**Subject:** Rezoning Petition Review

**Date of Review:** December 22, 2021 (*Revised February 25, 2022*)

**Rezoning Petition #:** 21-195

**Location of Property:** Approximately 60.65 acres located on the north side of W Arrowood Rd, east of I-485 and south of Shopton Rd.

PROPOSED BUFFER & LANDSCAPE AREAS

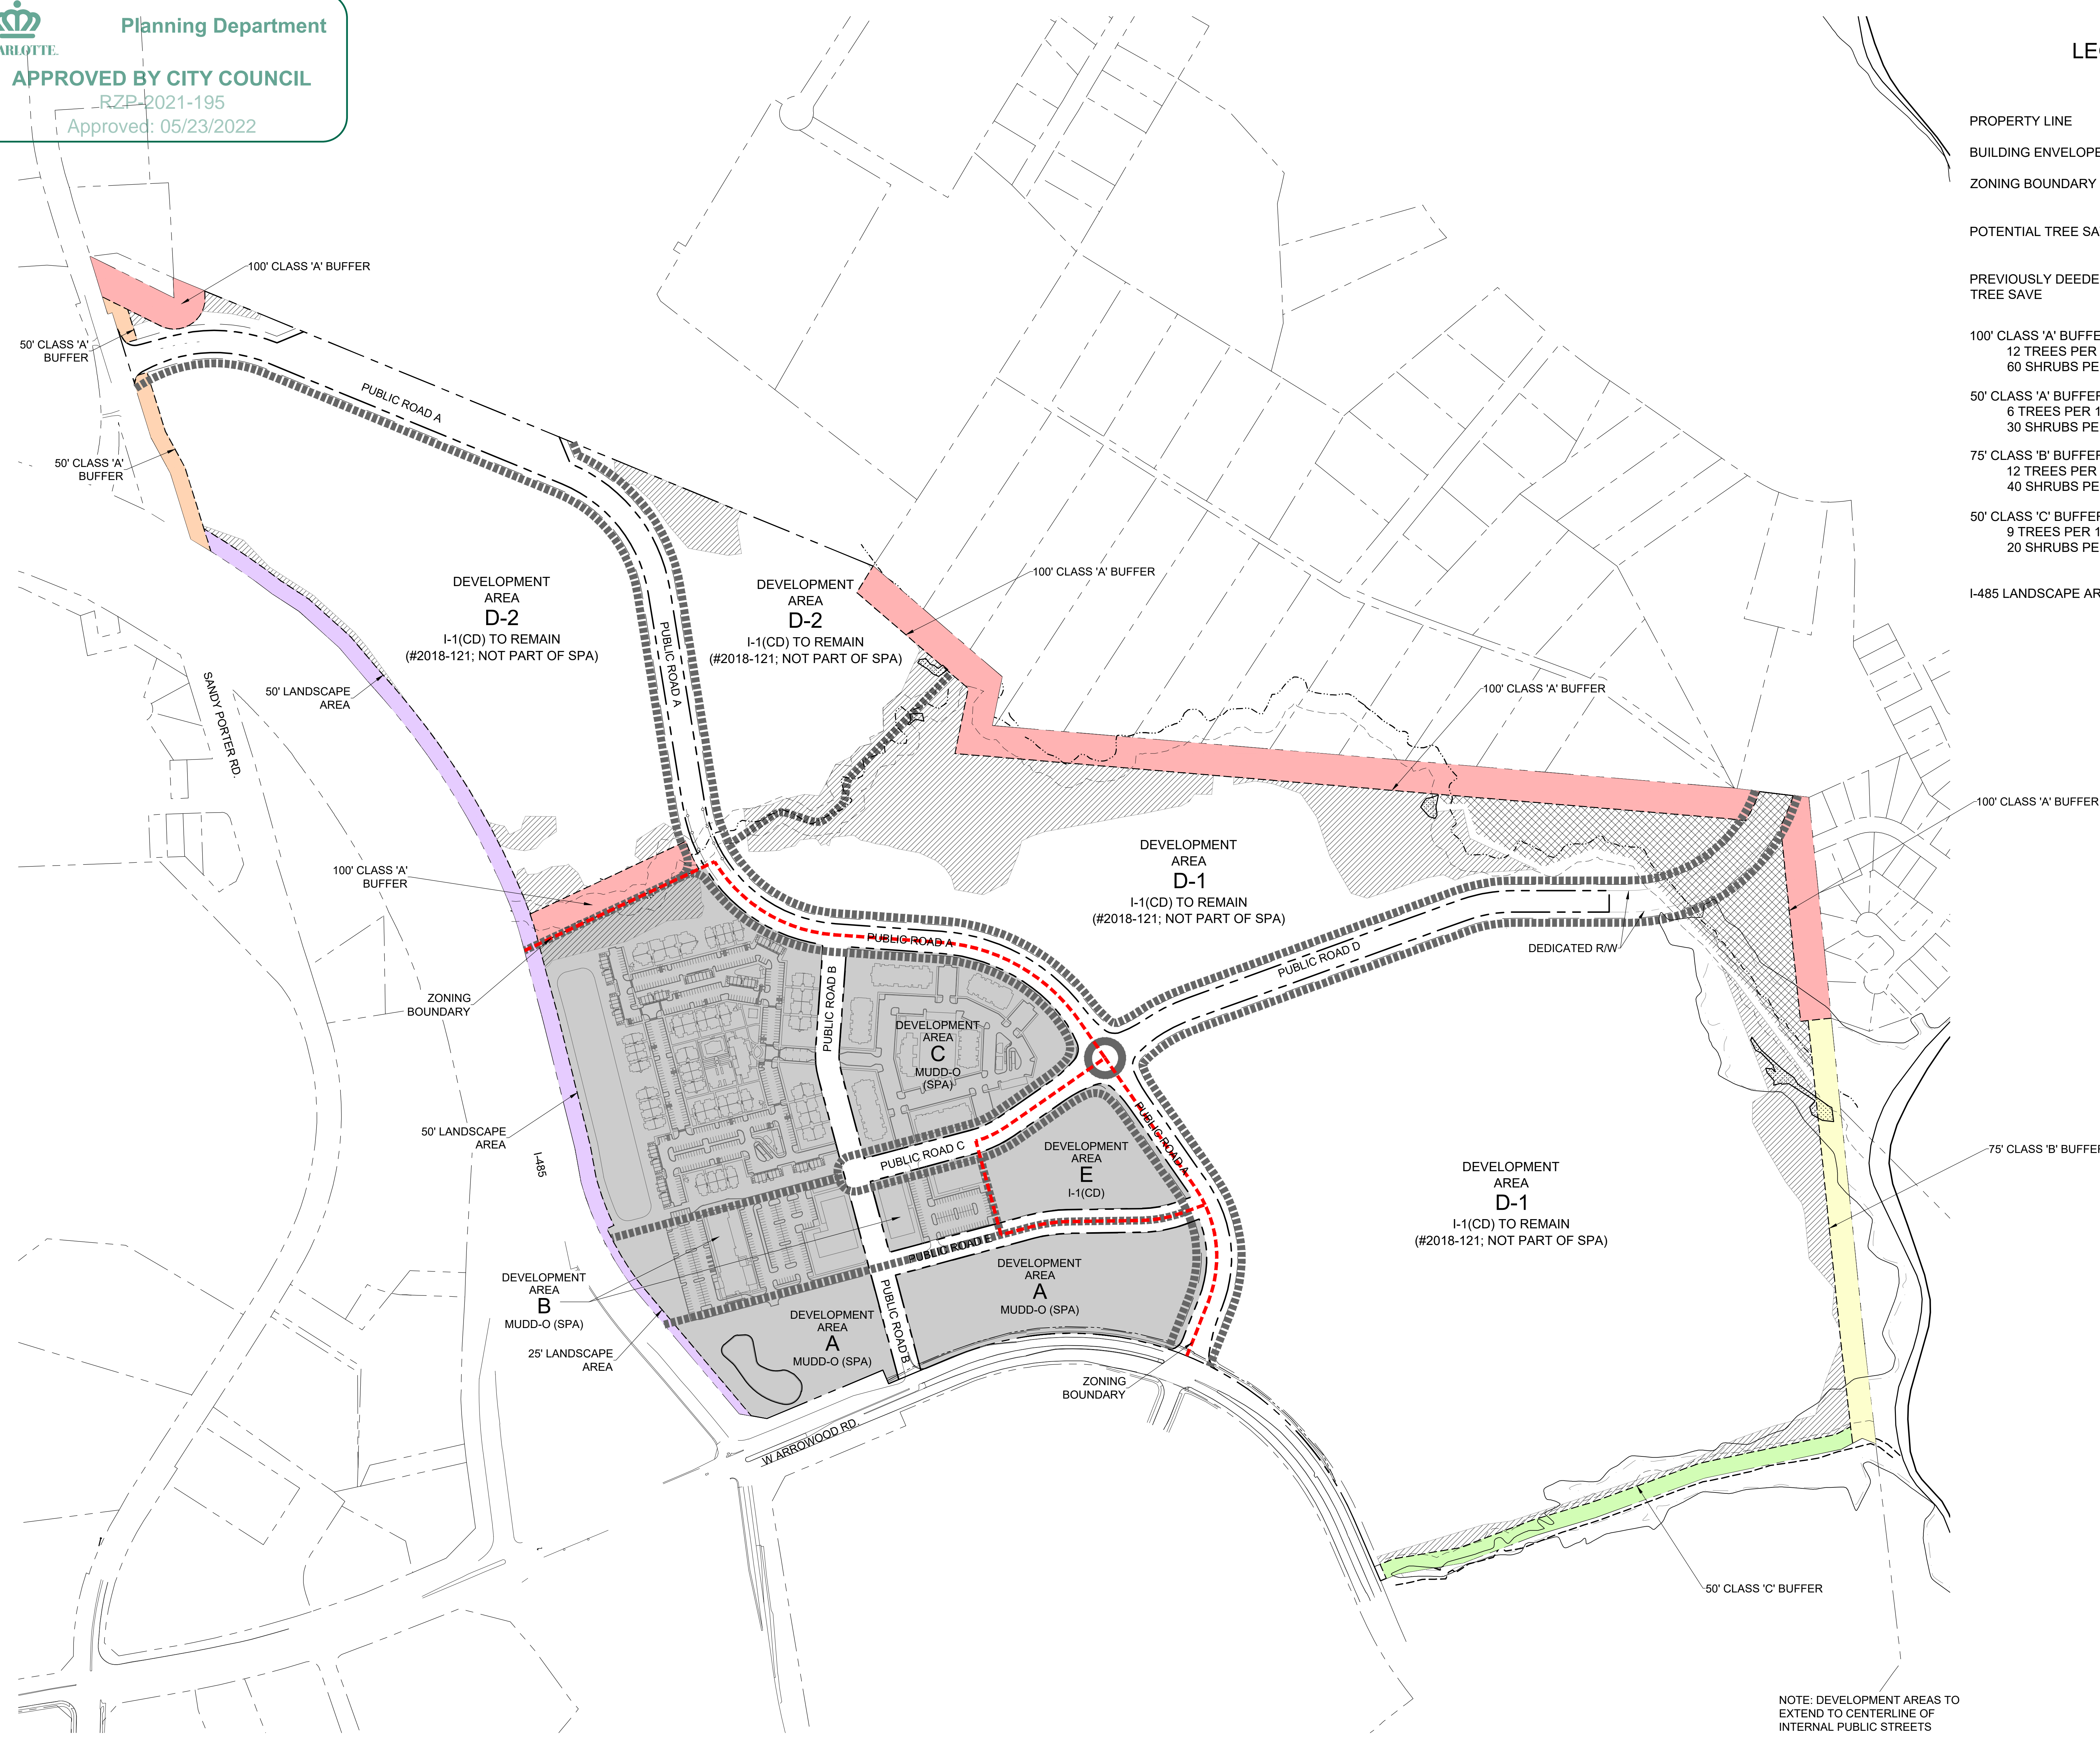
**Concerning Storm Water:** City of Charlotte GIS indicates a 30-ft PCSO Buffer on the site near/through Development Areas A and C. Please show all buffers and include the following note under Environmental Features: *“Development within any SWIM/PCSO Buffer shall be coordinated with and subject to approval by Charlotte-Mecklenburg Storm Water Services and mitigated if required by City ordinance. Petitioner acknowledges intermittent/perennial stream delineation reports are subject to review and approval upon submission of development plans for permitting and are not approved with rezoning decisions.”*
